Sydney Football Stadium (Stage 2 Design, Construction and Operation), 40-44 Driver Avenue, Moore Park (SSD 9835) - Notice of Exhibition

Thank you for your letter dated 17 June 2019, requesting Transport for NSW (TfNSW) review and comment on the above.

Figure 13 Existing bus routes to/from SFS

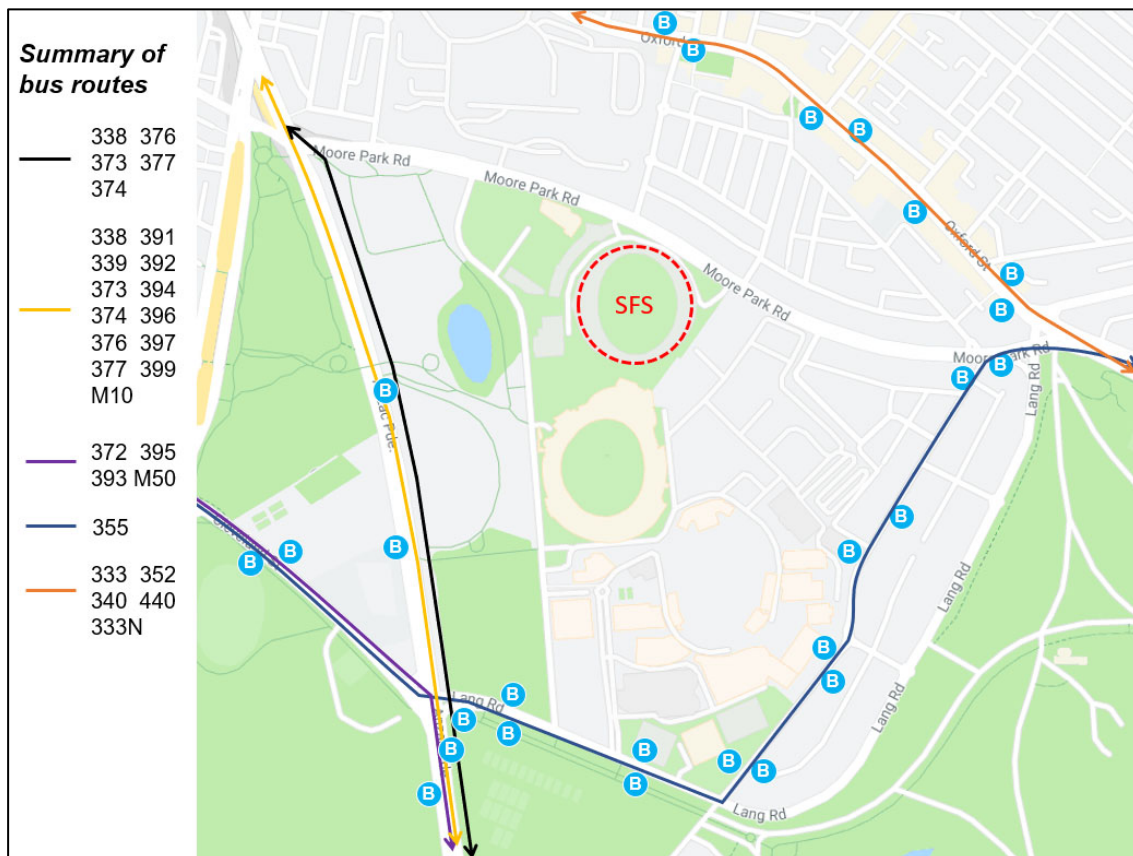
It is noted that the role of the existing regular bus network on the Anzac Parade/busway is briefly mentioned in the Transport Assessment. However, the details of bus stop and route information are either incomplete or inaccurate in the map of streets used by regular/individual bus services (p60 and p77) and the Amended Moore Park Precinct Operations Plan (Fig 19 and p44). The details are provided below:

- Route 333 on Oxford Street is not mentioned and Route 380 has been withdrawn from the road as of September 2018; and
- Stops in the busway at the Lang Road intersection and Route 355 stops in Lang Road are not shown. By contrast the map of key pedestrian routes on p19 (Fig 5) shows the stops on Anzac Parade at the Lang Road intersection. Stops are also shown on the busway near this location but they are not referred to in the text.

It is requested that the applicant amends the Transport Assessment to include accurate details of bus stops and bus services.
